**Subject:** Exhibition – Lang Walker AO Medical Research Building - Macarthur (SSD-17491477)

**Attachment A – EES comments on the Environmental Impact Statement for the Lang Walker AO Medical Research Building - Macarthur (SSD-17491477)**

Figure 19 - Provisional Flood Hazards (PMF) – Proposed Conditions

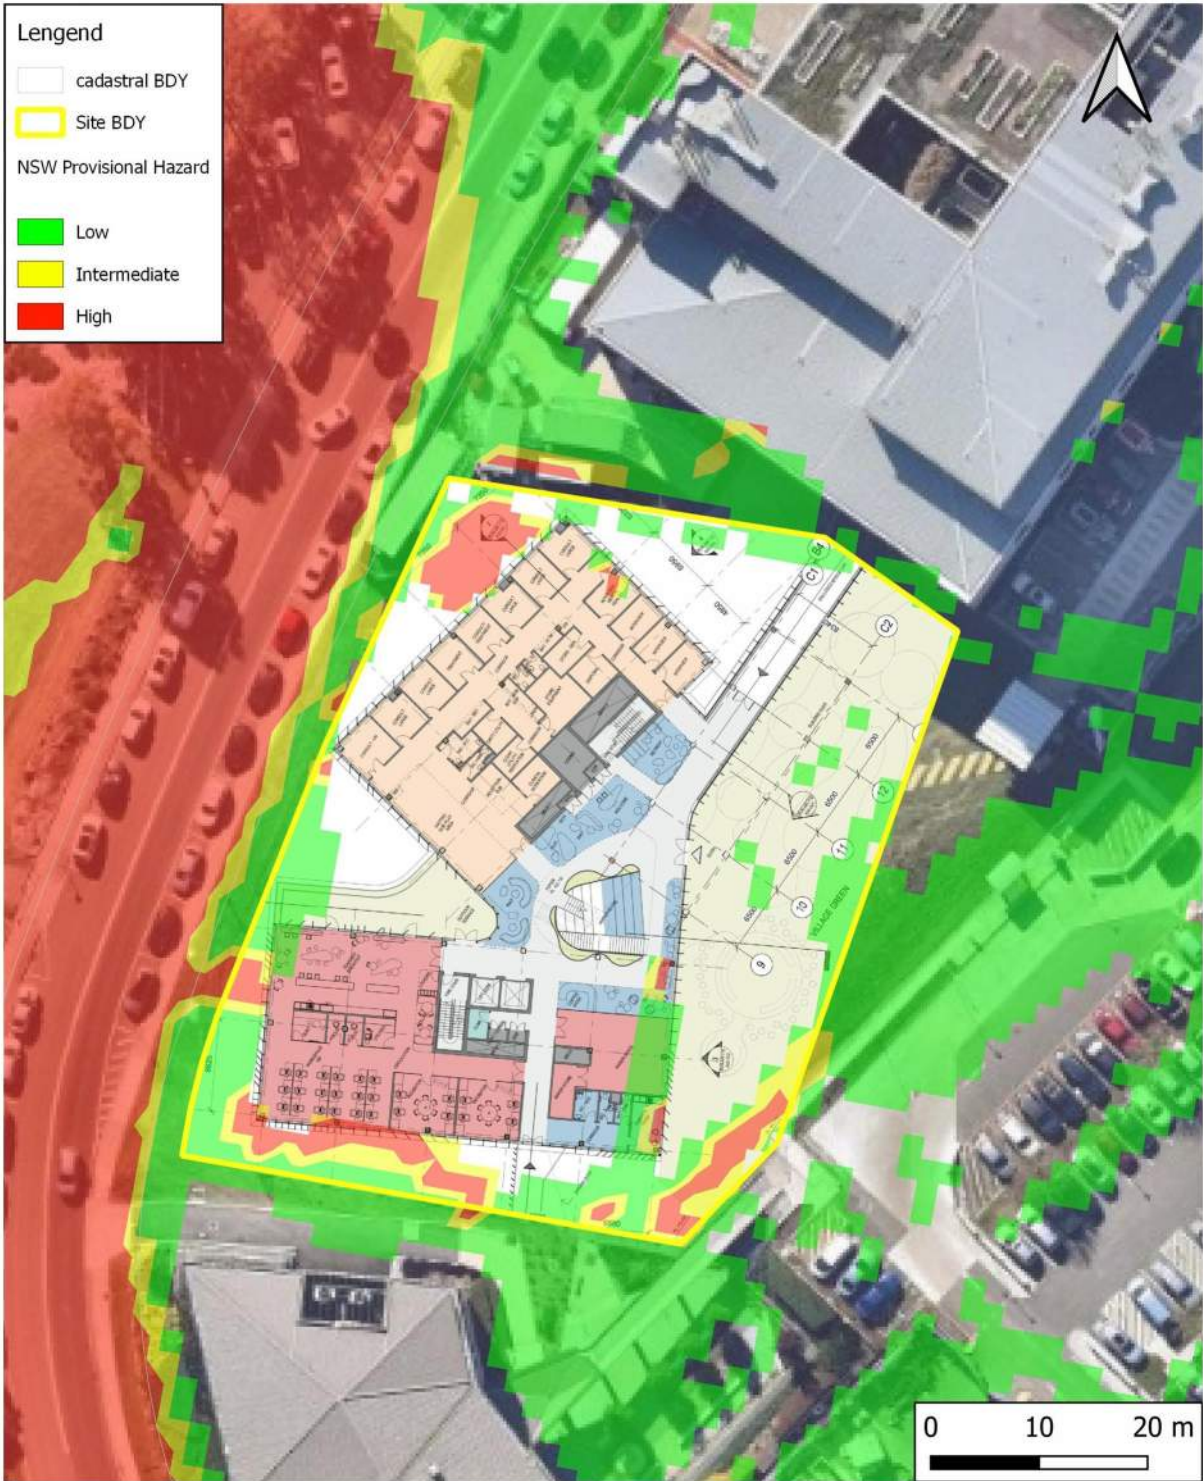
EES has concerns regarding the flood model accuracy. The proposed conditions flood mapping shows flooding inside the building footprint, most notably in Figure 19 of the *Civil SSDA – Flood Assessment and Stormwater Management Report Lang Walker AO Medical Research Building – Macarthur* (the flood report). The building should be blocked out in the model and no flooding should be present within the building footprint. If the building is not blocked out, impacts will not be properly assessed.
